HIGHMOOR FARM, CLITHEROE

LLFA RESPONSE
REVISION A

17th June 2026

- 1.1 This report has been produced to provide a formal response to the drainage comments provided by the Lead Local Flood received in May 2026 relating to the planning application (3/2026/0314).
- 1.2 The comments provided by the LLFA are set out below along with a designers response, in blue, to each.

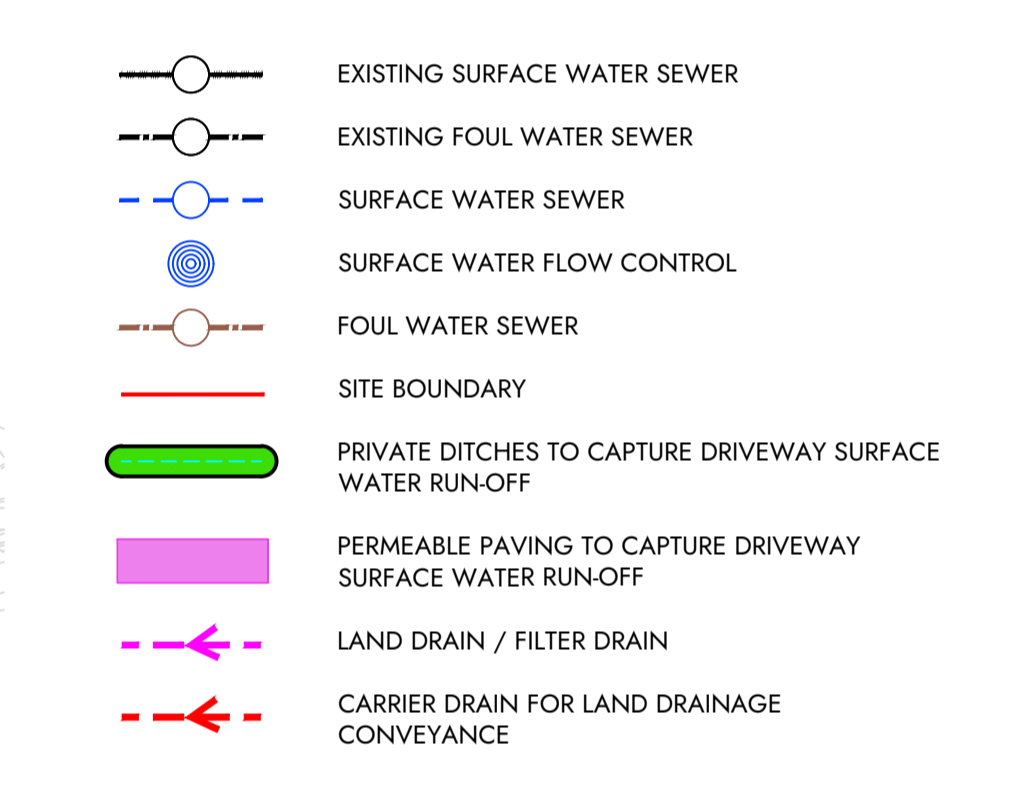
- 2.1 The Lead Local Flood Authority cannot recommend the discharge of condition 23 on planning decision 3/2020/0601 on the basis of:
- The applicant has provided evidence within the catchment plan of a contributing area of approximately 2.444ha, however the applicant has provided evidence of the greenfield scenario being based on 3.973ha, giving a Q_{bar} of approximately 37.5l/s, although this approach was acceptable in principle, the contributing areas used to calculate the existing scenario and the proposed development are expected to be consistent. Should the applicant only intend to drain the impermeable areas (including the area for the proposed basin) then the proposed final discharge rate should also be based on the same contributing area.

A surface water catchment plan has been provided in Appendix A. The surface water catchment plan indicates the contributing areas that have been used to calculate the existing runoff rate. Likewise, the areas have been used within the surface water calculations which are provided in Appendix B.

The total developable area of the site including the basin area, but excluding permeable POS, is 2.451ha. This area provides a greenfield runoff rate Q_{bar} of 23.1l/s. The revised greenfield runoff rates are provided in Appendix C.
